MEMORANDUM

SUBJECT: SF-19-013 – Creekside at Lorson Ranch
Second Submittal – response to comments

Channel Construction Plans and Design Report (also in CDR-19-002)

LORSON RANCH
CREEKSIDE DEVELOPMENT
EAST FORK JIMMY CAMP CREEK
CHANNEL PLAN AND PROFILE STA 10+00 TO STA 22+00
EL PASO COUNTY, COLORADO

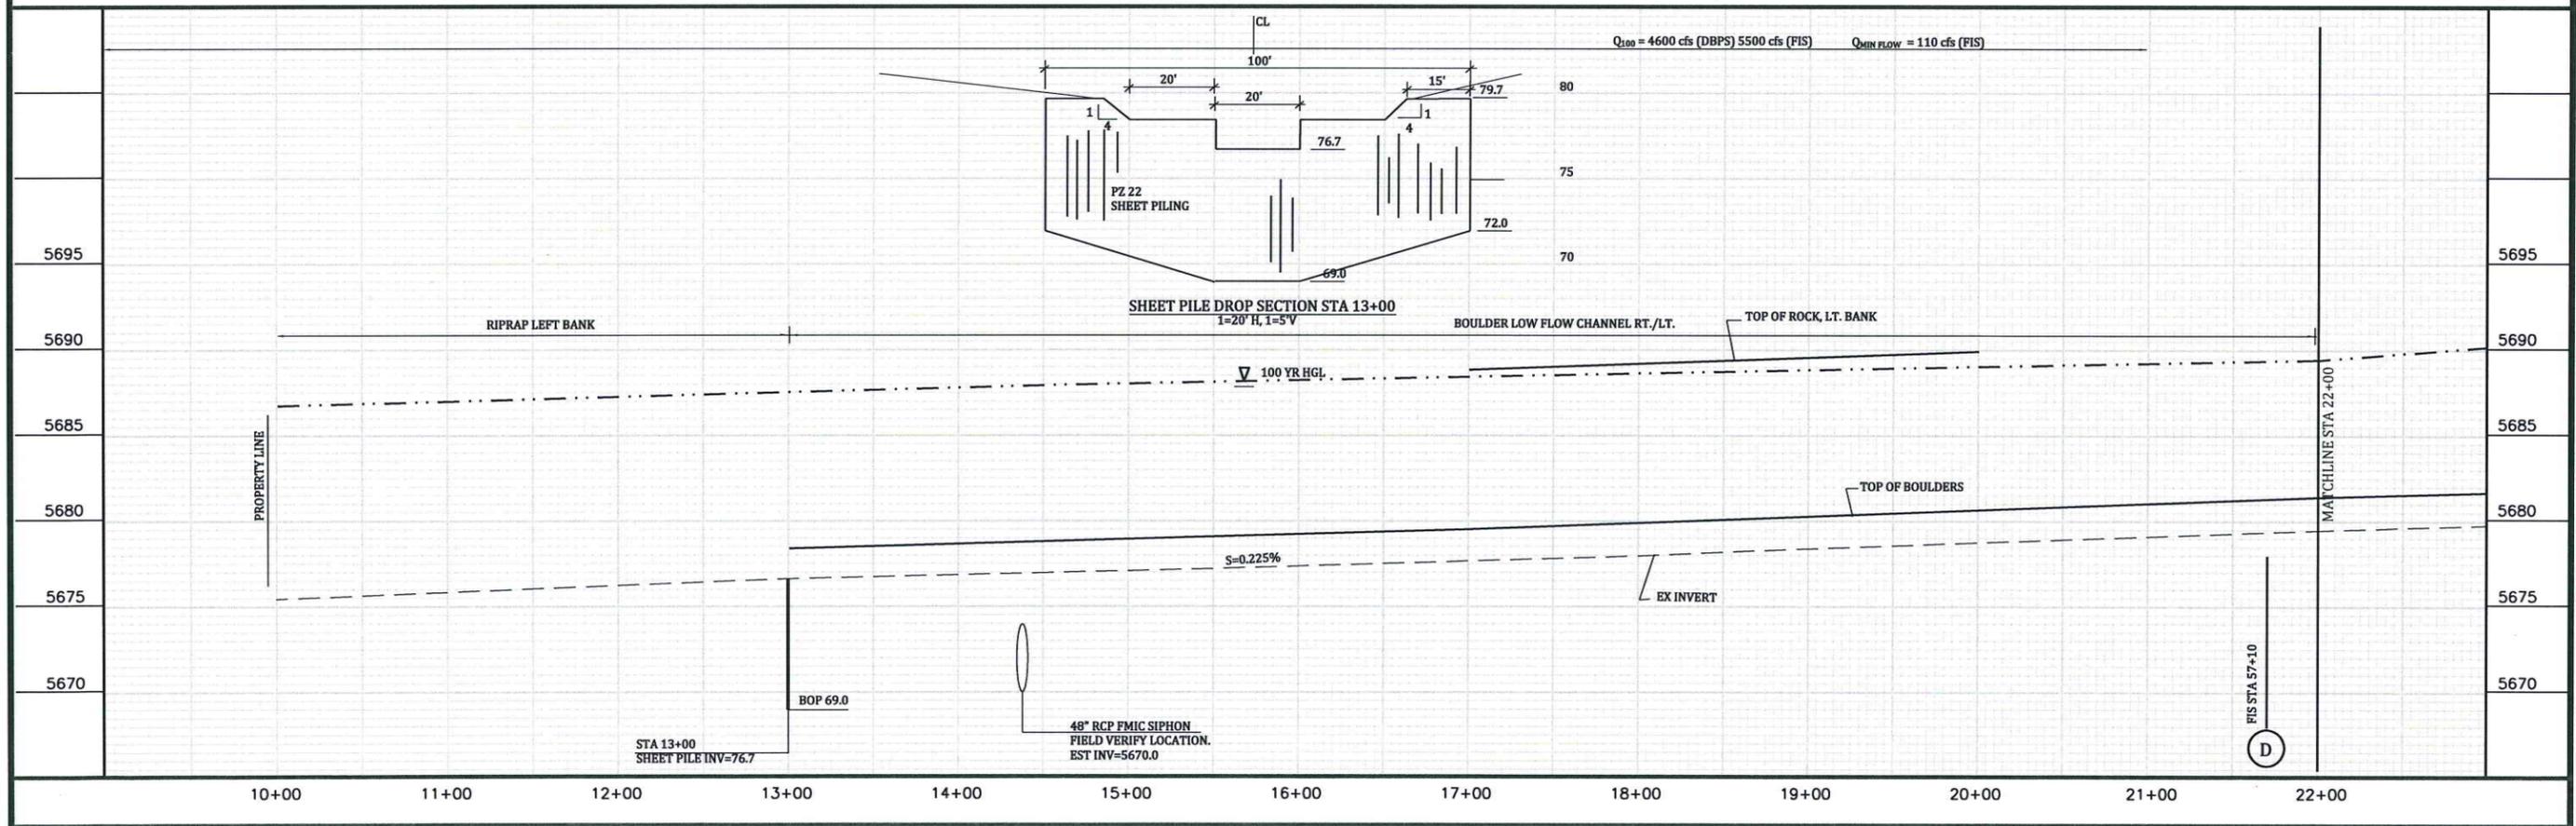
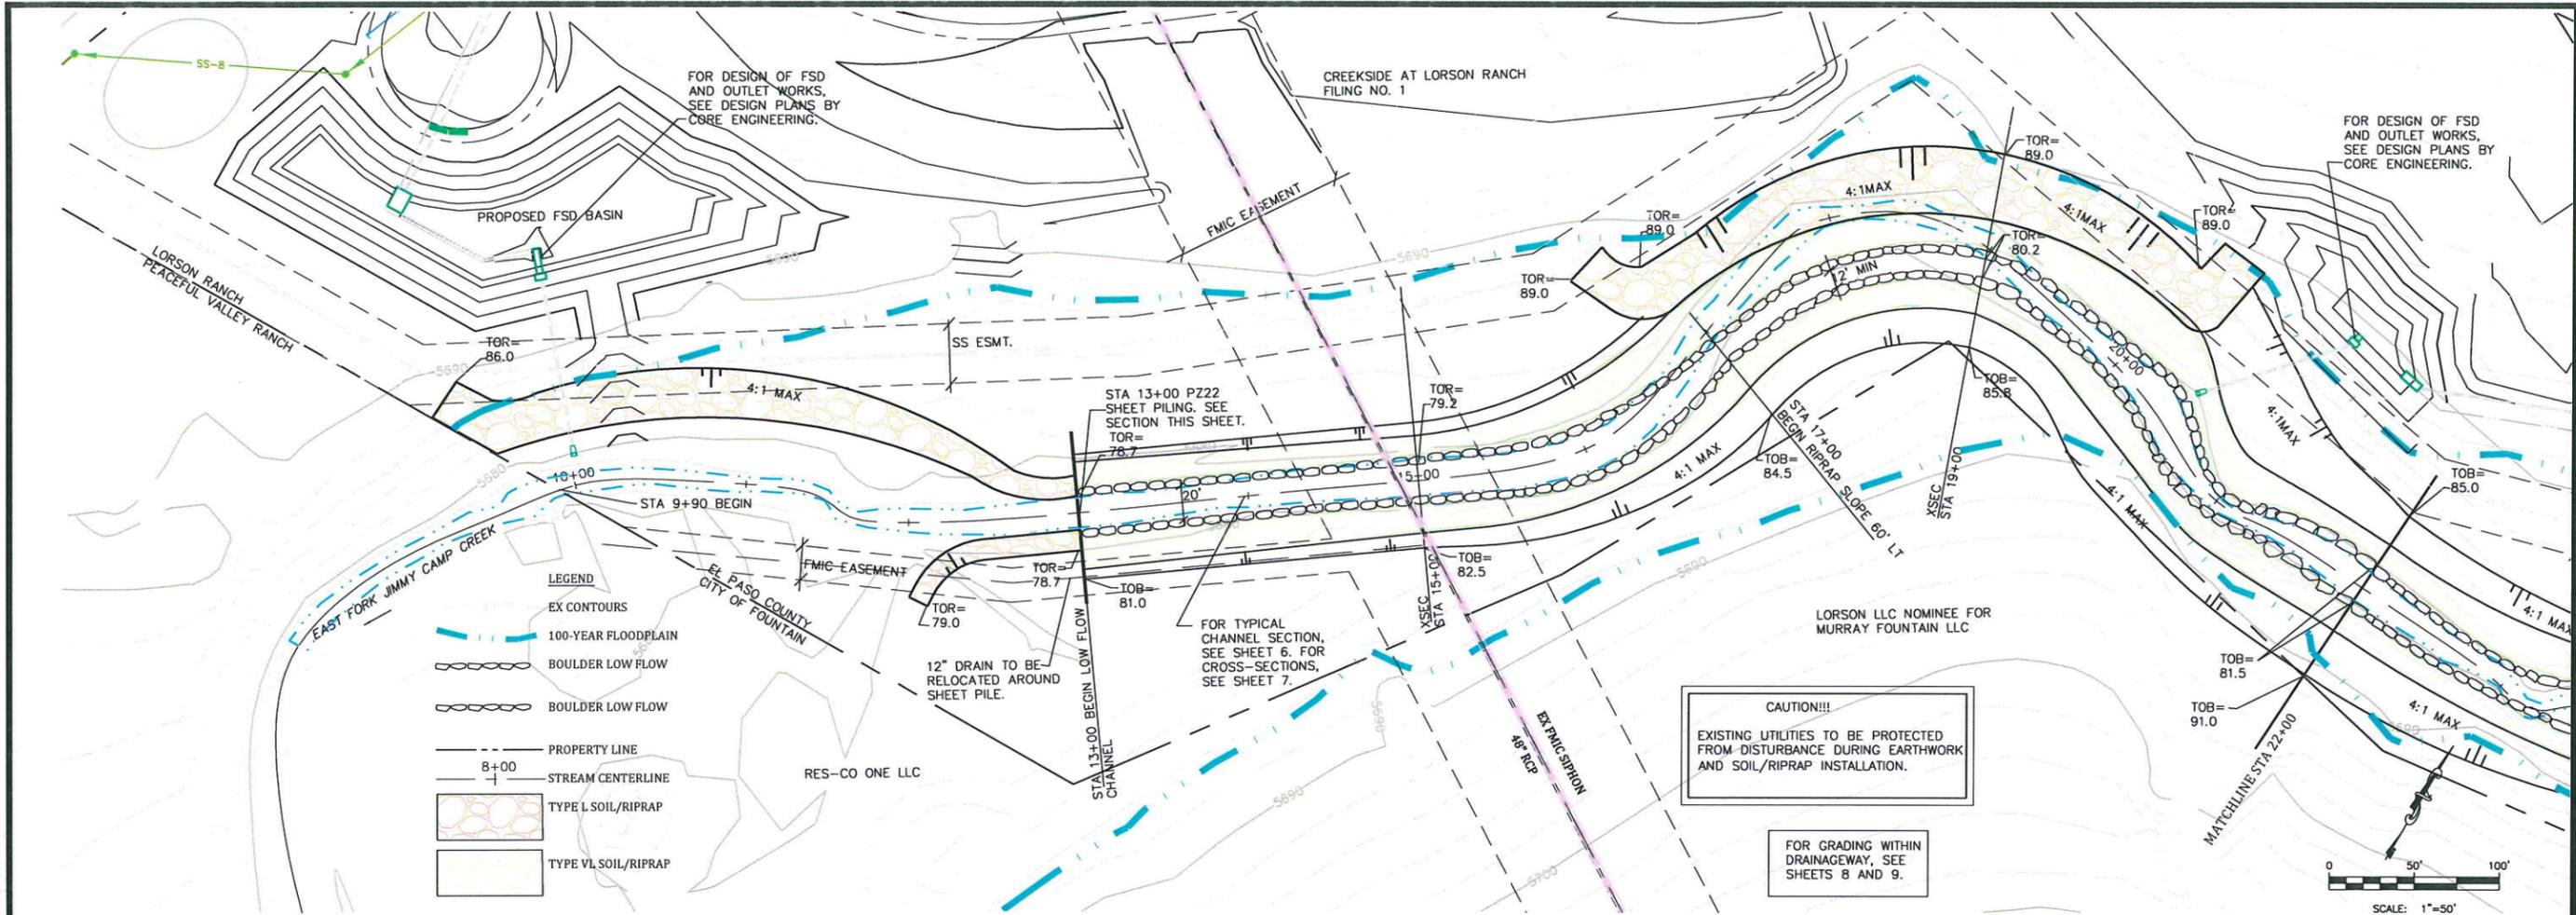
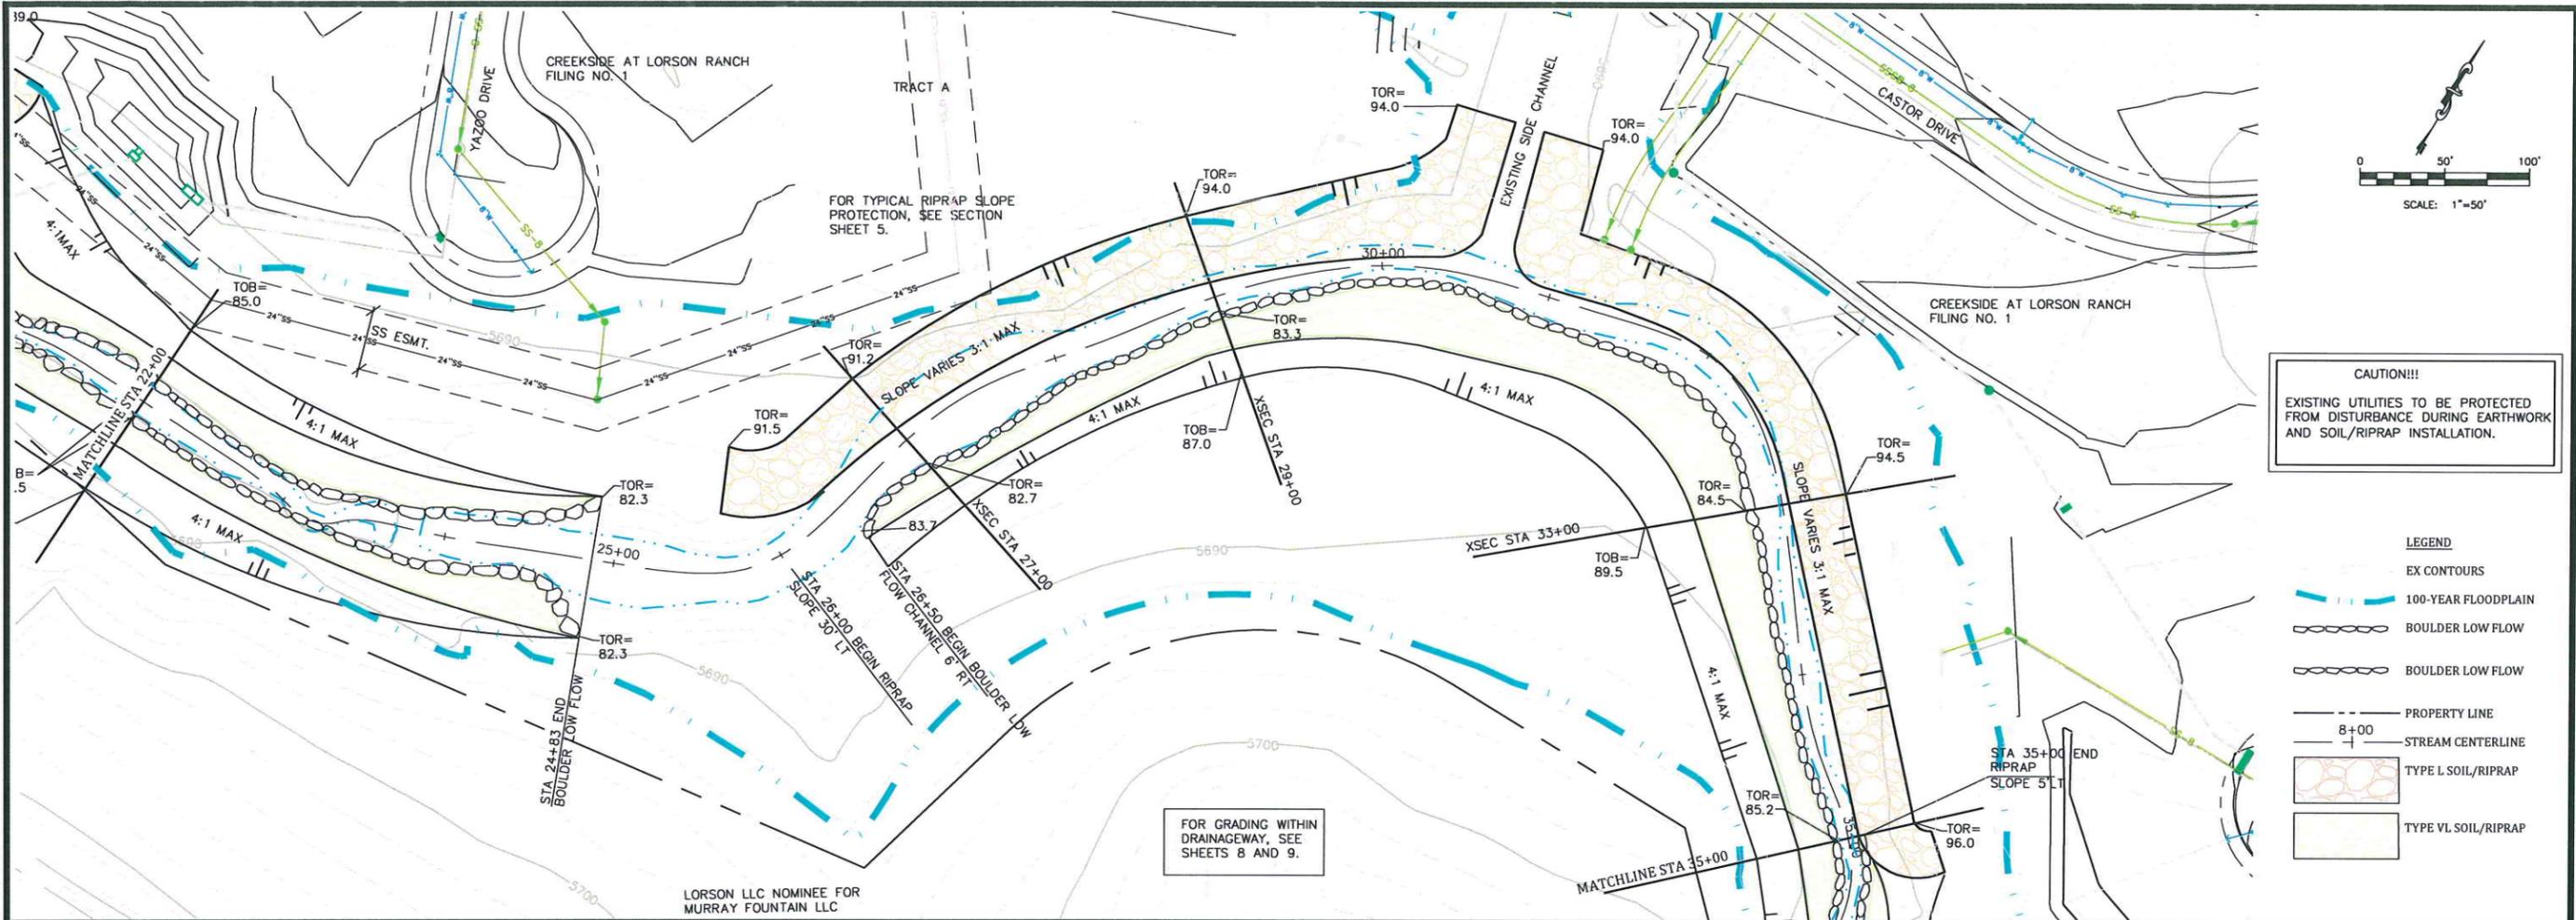
4. **The channel profile grade labels appear to be spot labels of existing grades. Clarify with additional labels or clearly label the average overall grades between stations based on the design.**

5. **It appears that at least one additional grade control (drop or check) structure is required between the two proposed structures to minimize potential channel degradation. Consider placing a drop or check structure at the location of a drop structure shown in the DBPS corresponding to Station 30+00 on the plans. Reference UDFCD Chapter 9, Section 2.9. Please discuss with Staff.**
